2024/0844

Address: 10 Kexbrough Drive, Kexbrough, Barnsley, S75 5EY

Description: 1st floor side extension (above existing single storey side extension), and single storey rear extension to 2 storey detached dwelling.

Proposed First Floor Plan 1:50 @ A1

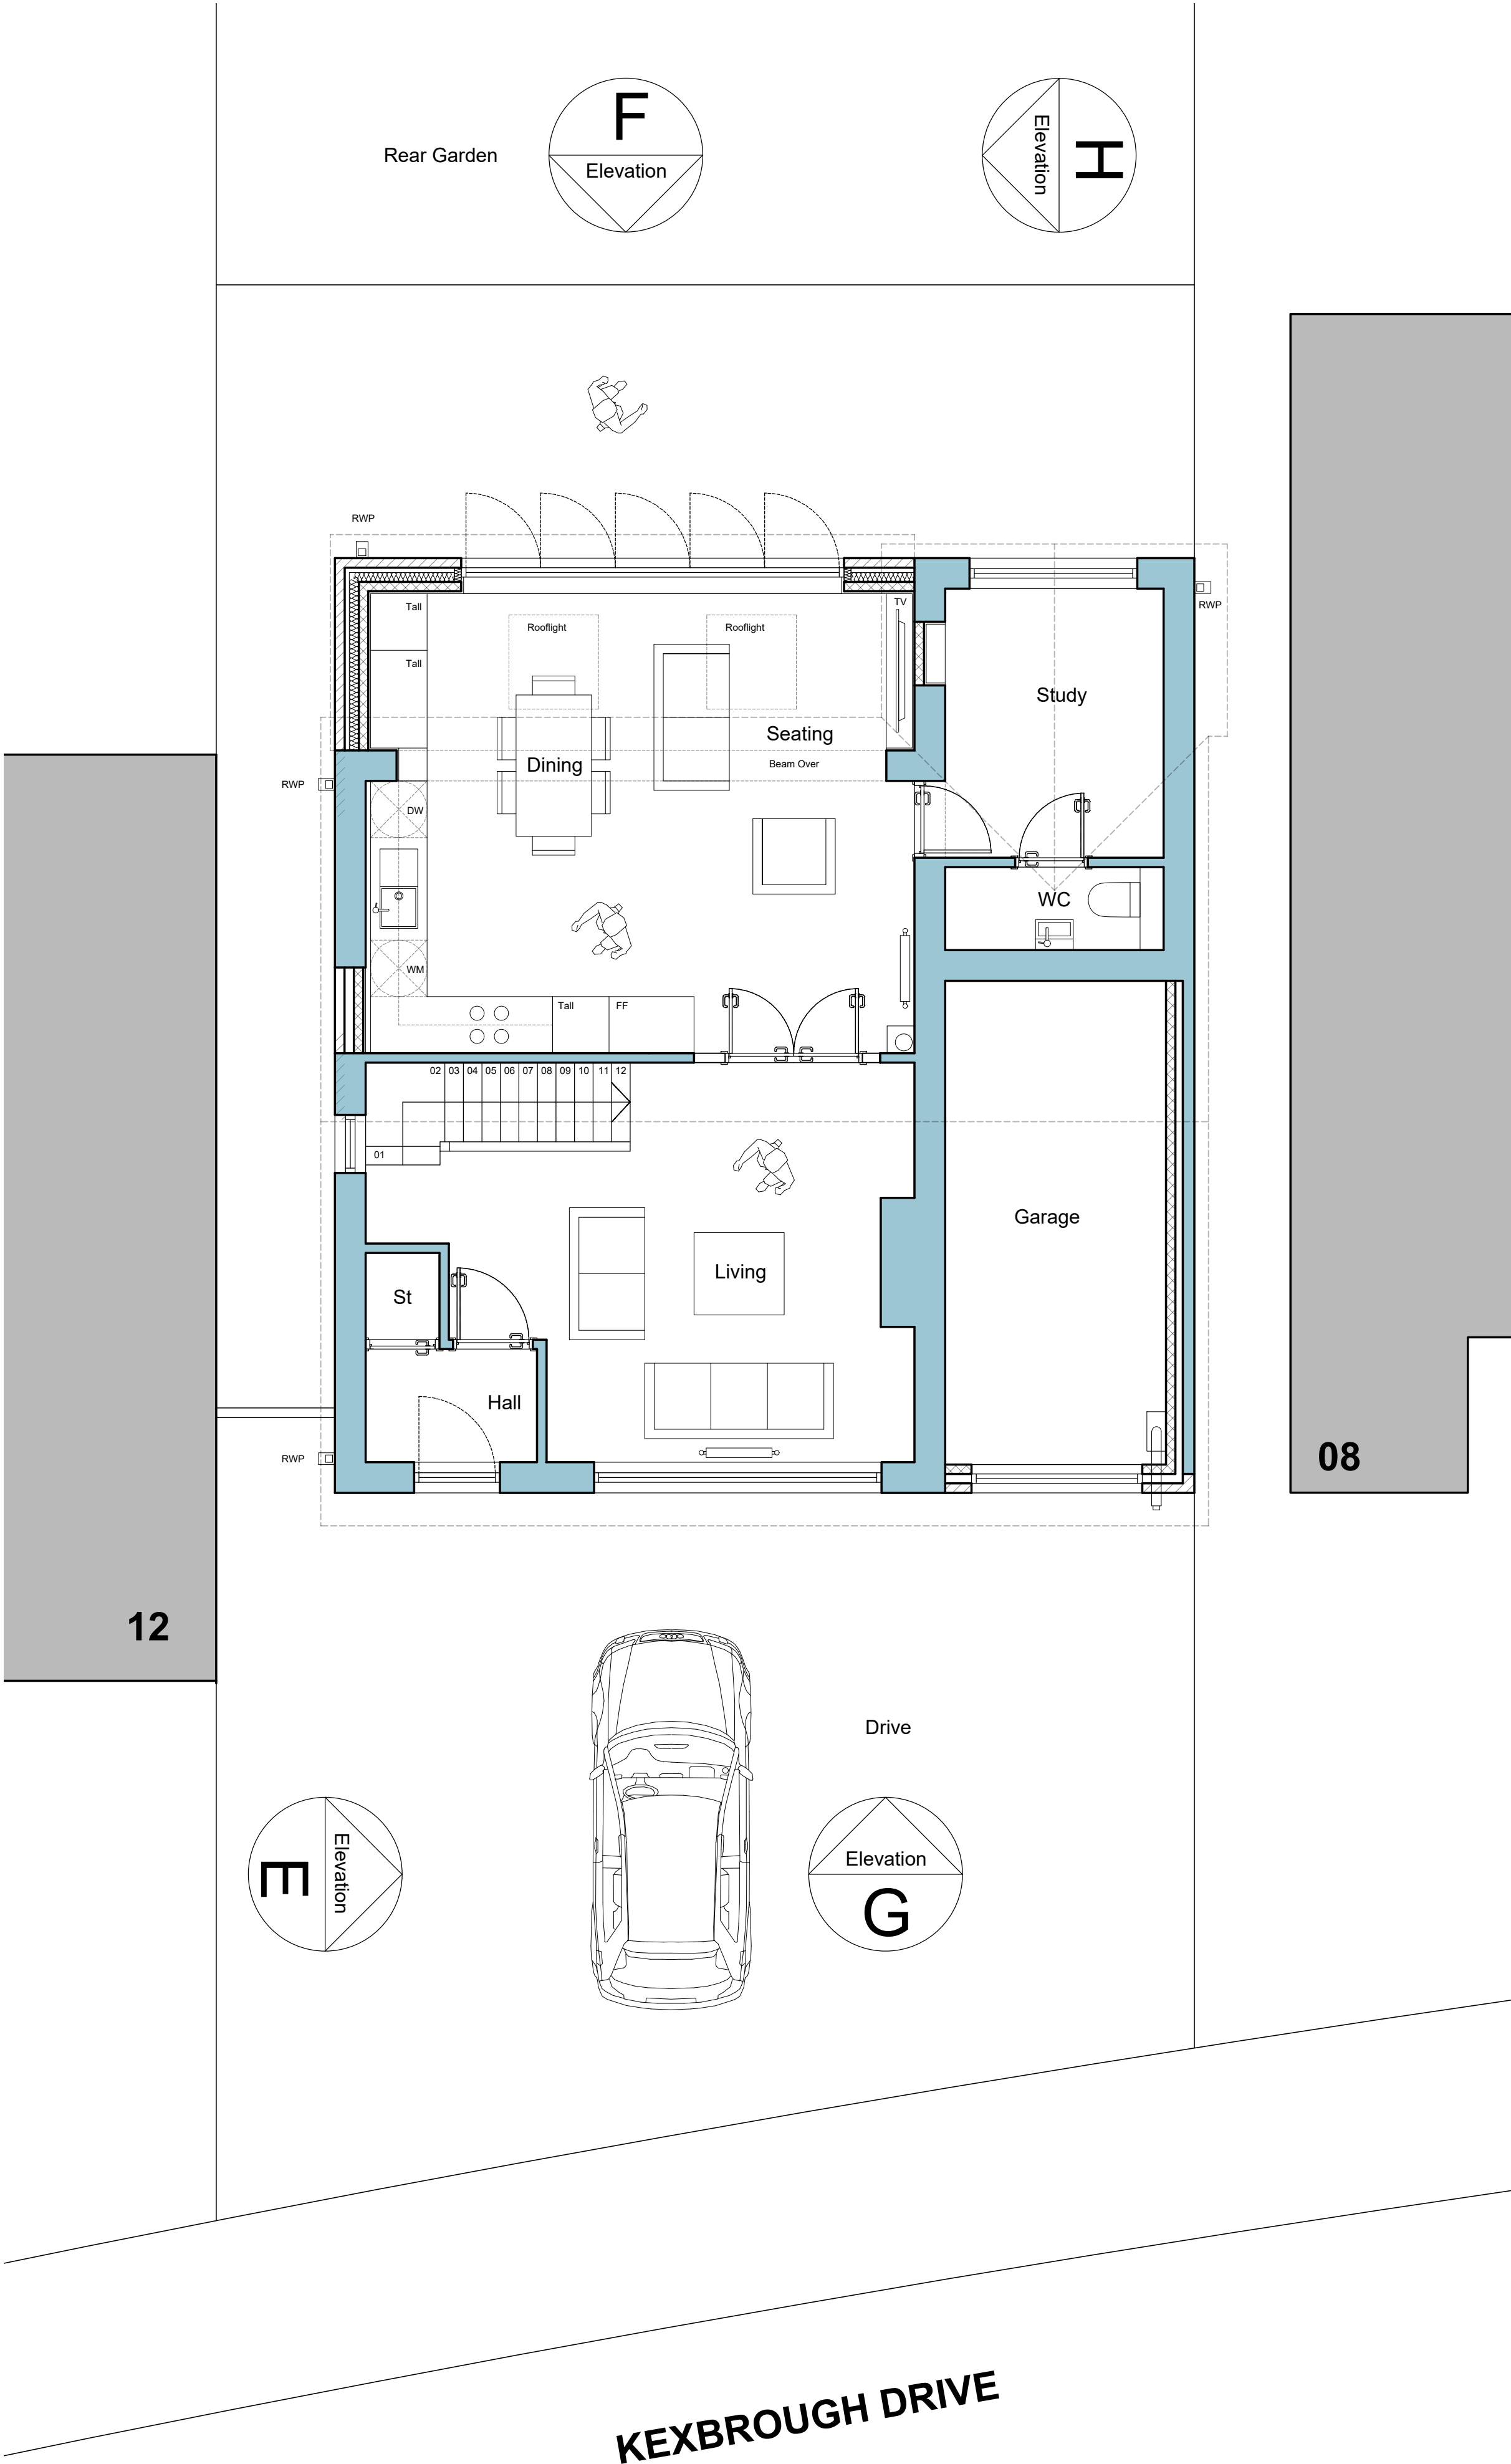
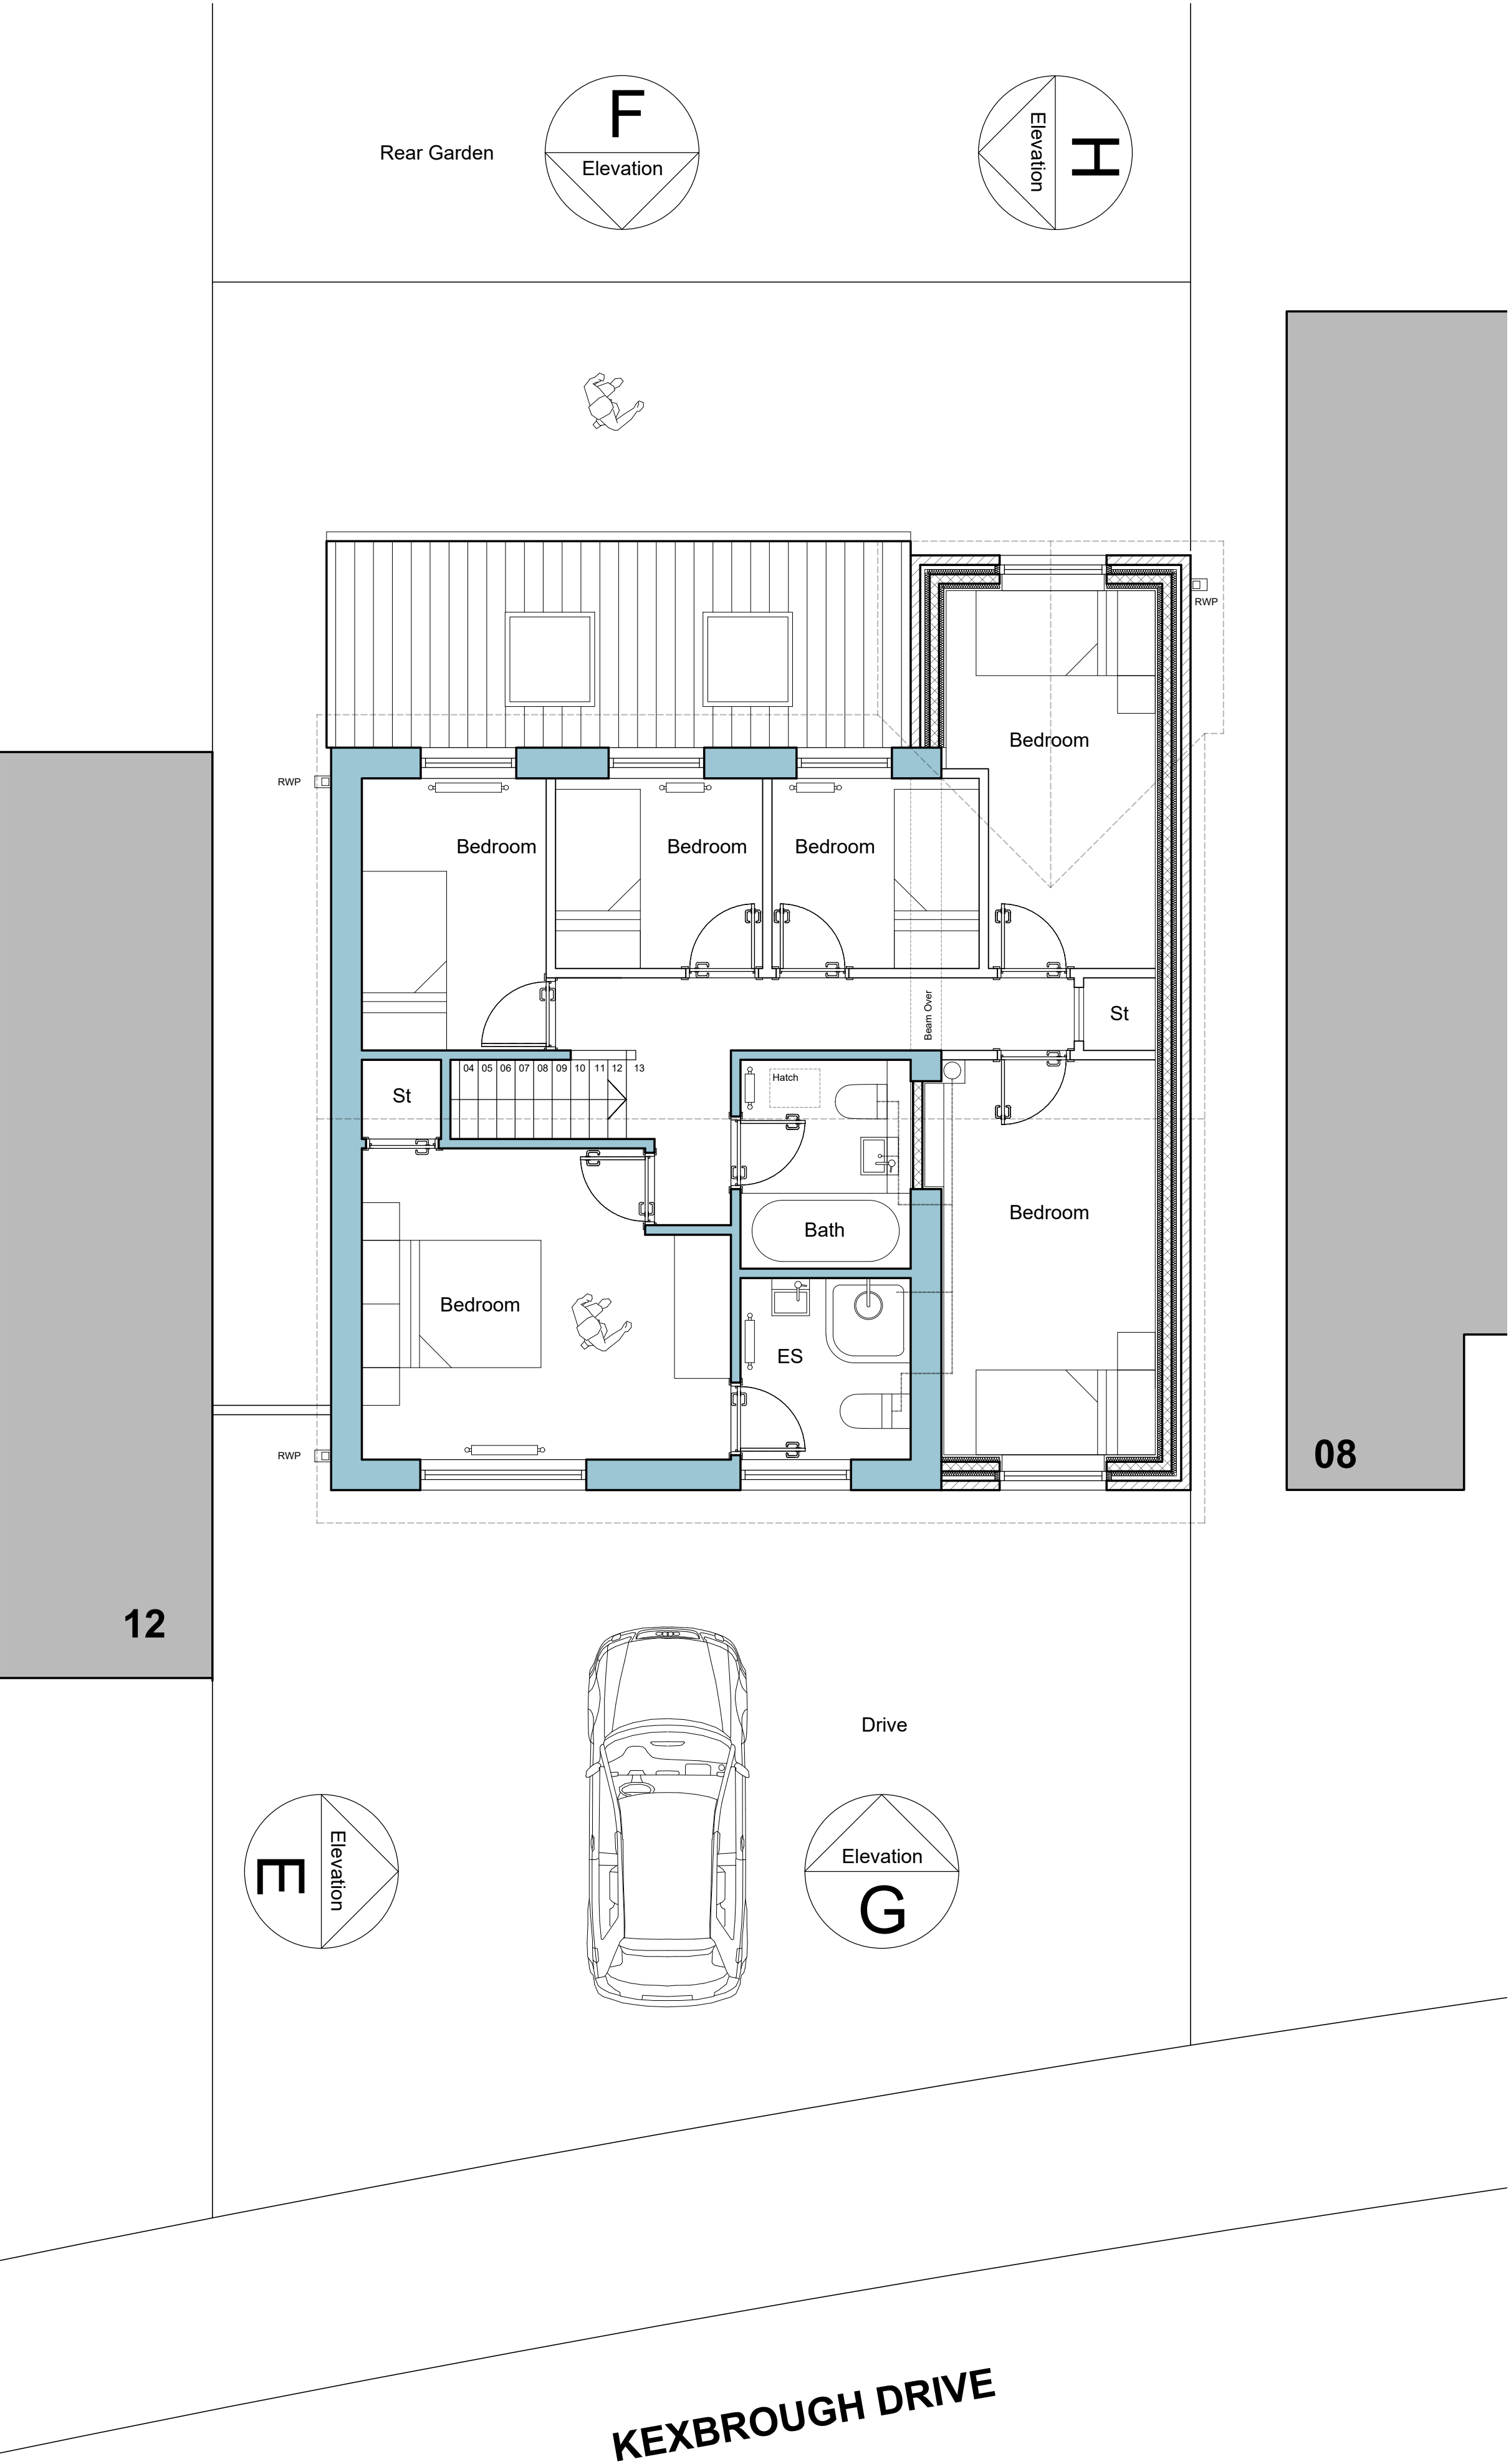
On this occasion the distance from the proposed first floor extension, which is a first floor to an existing ground floor structure is between 8.39m and 8.8m. A key intention of the 10m rule is to protect the privacy of neighbouring dwellings, particularly their rear gardens. Having checked the potentially affected area of the neighbouring garden, which may be overlooked by a single proposed first floor window, the amount (percentage), location, and distance from the main neighbouring dwelling would be of an insignificant impact. The neighbour's rear garden is at least 259sqm in size, of this vast area, an area of approximately of 32sqm or 12.5%, located in the far corner of the garden, behind the detached garage, and over 10m from the corner of the rear elevation of the dwelling, may potentially be overlooked by the proposed window. The other rear garden which may be negligibly overlooked is not a residential address. The distance from the indirectly overlooked rear windows of the neighbouring dwelling would be at least 21m whilst the distance to indirectly overlooked windows of the non-residential dwelling would be a minimum of 17m. Furthermore, the addition of 1no. Additional secondary bedroom window would not significantly increase overlooking compared with the current situation.

The garage door has been slightly reduced in size, which may inhibit use of the garage for larger vehicles. Other access and parking provisions are unaffected, including the block paved front garden which provides sufficient space for at least two vehicles. As such, there would be no impact upon highway safety.
